Appeal Decision

Appeal Ref: APP/A2525/D/25/3358549

1 Herdsman Close, Deeping St. Nicholas, Lincolnshire PE11 3AE

- The appeal is made under section 78 of the Town and Country Planning Act 1990 (as amended) against a refusal to grant planning permission.
 - The appeal is made by Jane Wenman against the decision of South Holland District Council.
 - The application Ref is H03-0797-24.
 - The development proposed is described as 'garage extension to form an annexe.'
-

TITLE
Proposed Ground Floor Plan
Proposed Elevations

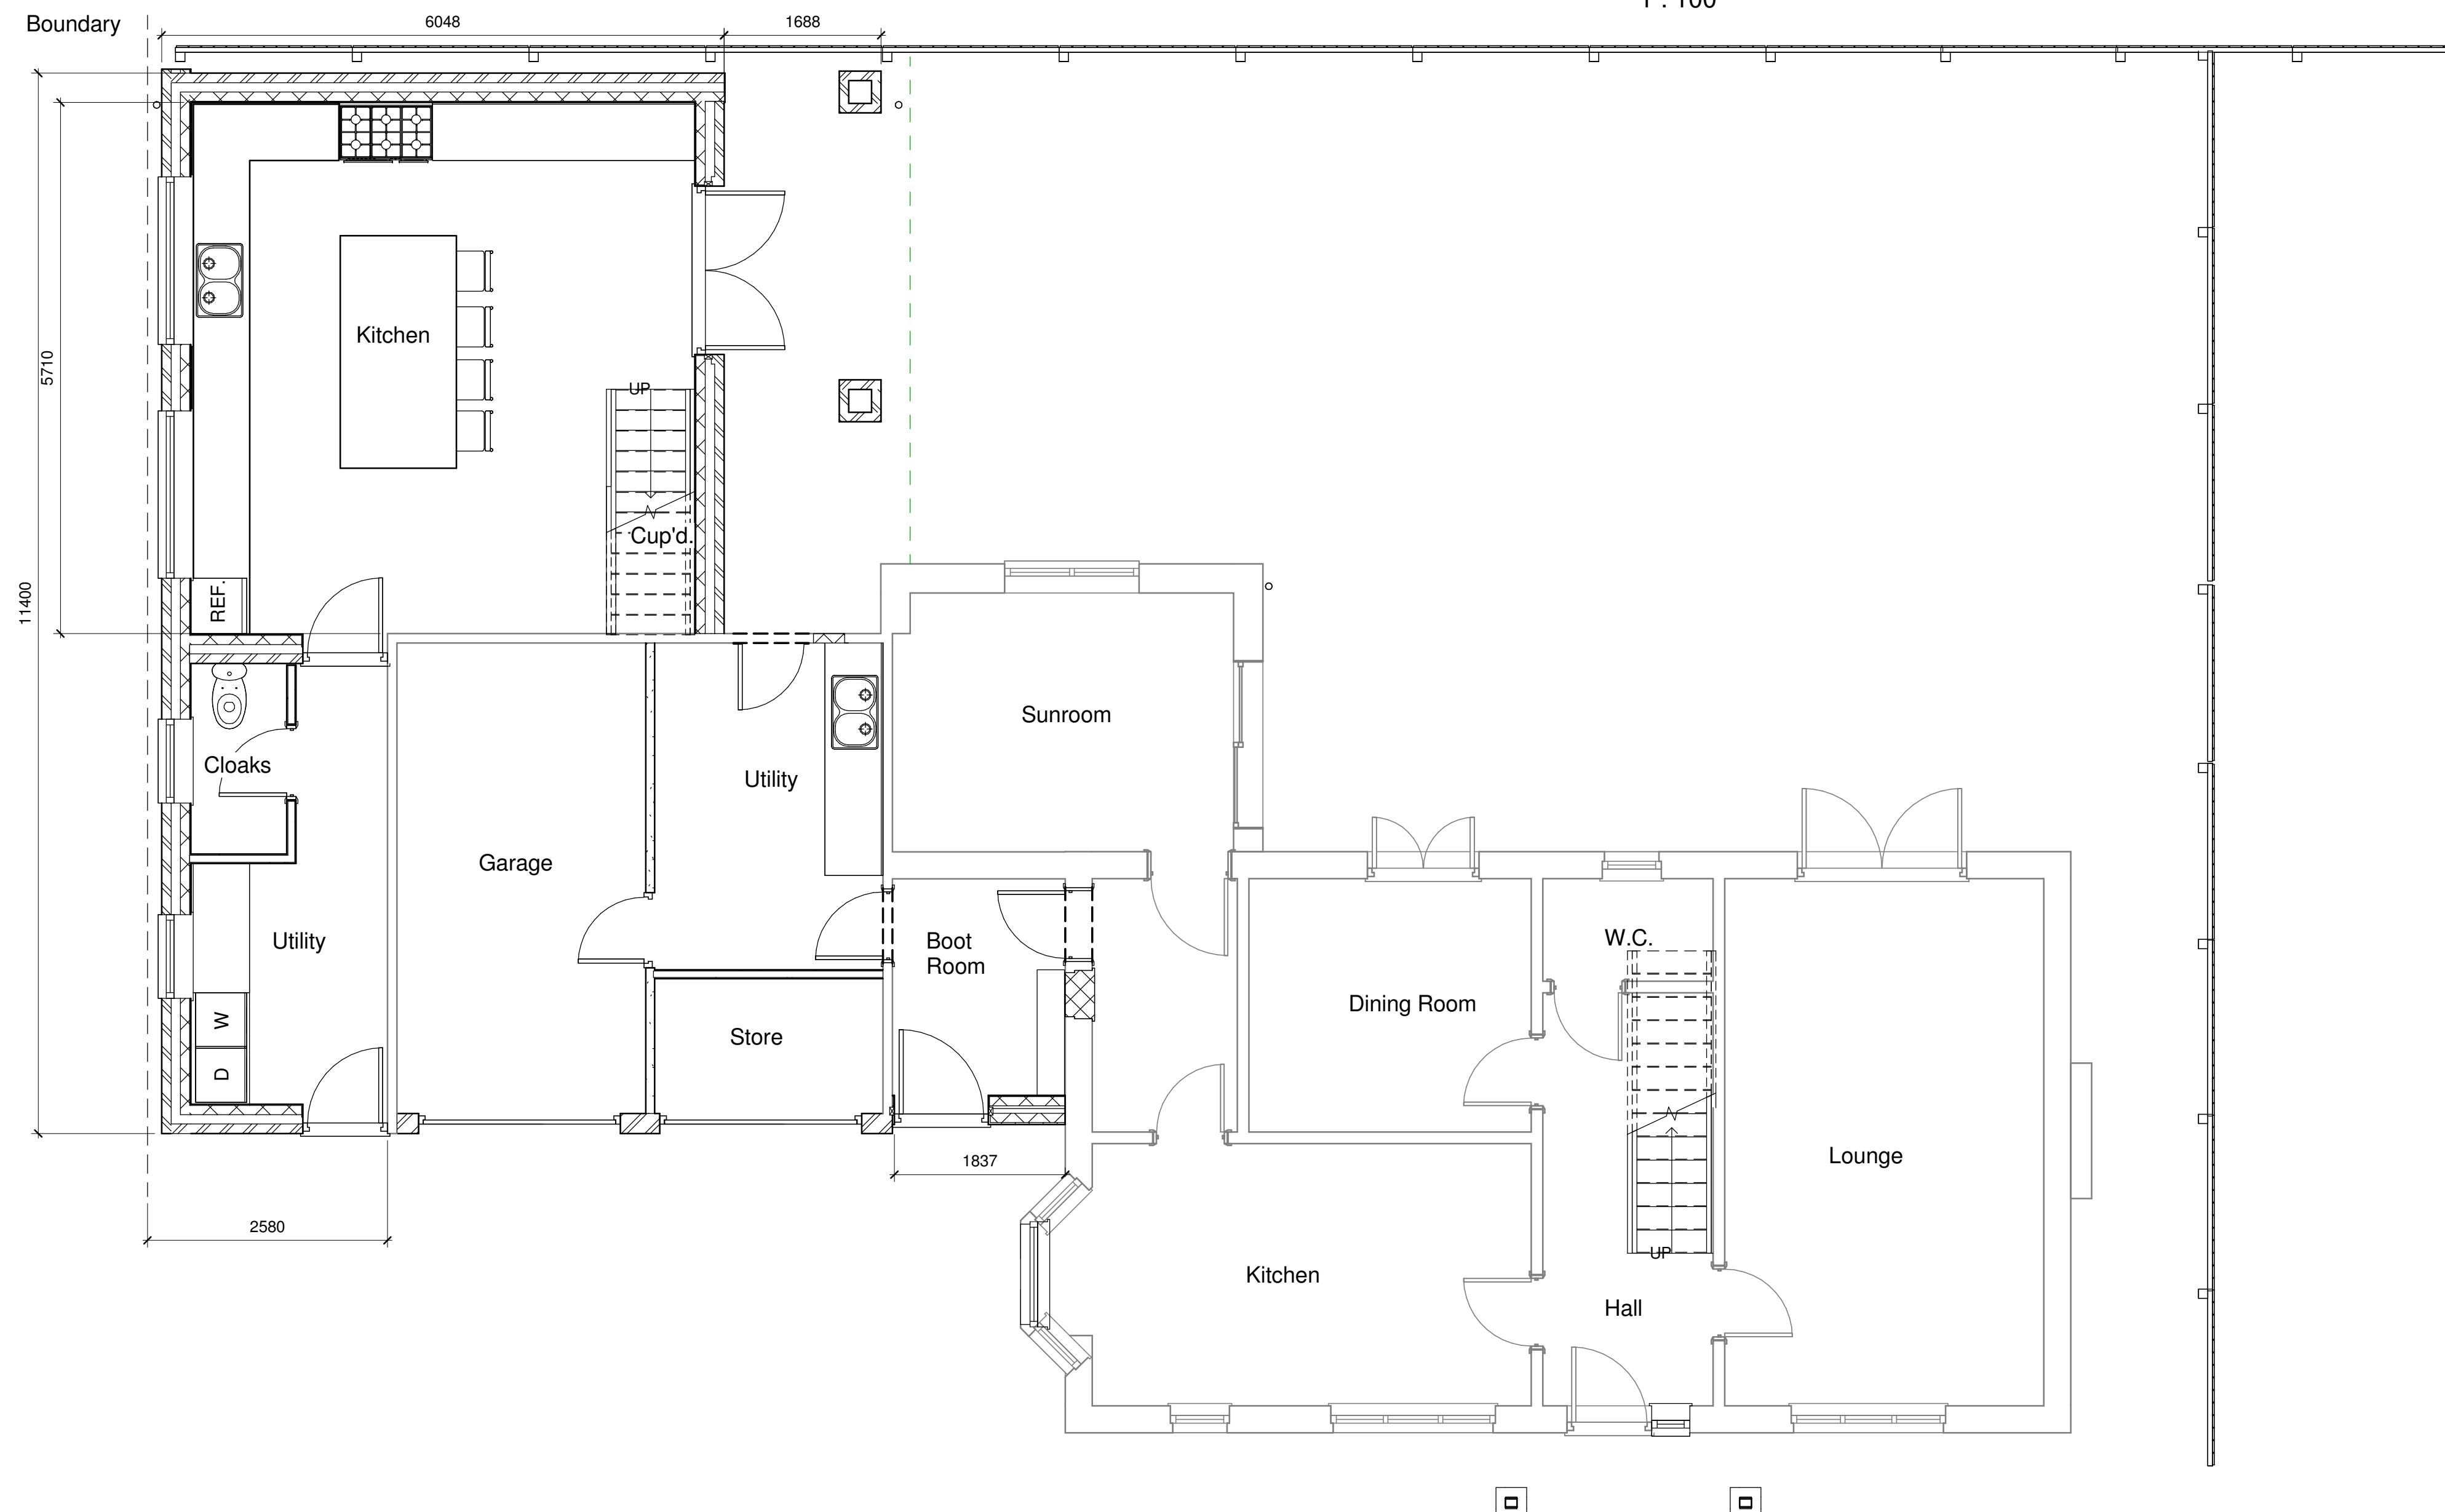
5. Due to its elongated form and scale, the increased height and length of the annexe would add considerable bulk and massing to this component of the host property. The resulting change to its architectural composition would raise the status of the currently subservient linked garage relative to the main body of the house. Its roof form, at this scale, would jar with the existing dwelling and despite being slightly set down in height, would still visually compete with it in the street-scene. Its prominence would be exacerbated by it being set further towards the highway than the existing garage and other built form in the locality. Overall, these changes would harmfully disrupt and undermine the sense of spaciousness generated

through the careful placement and limited scale of development adjacent to the highway.
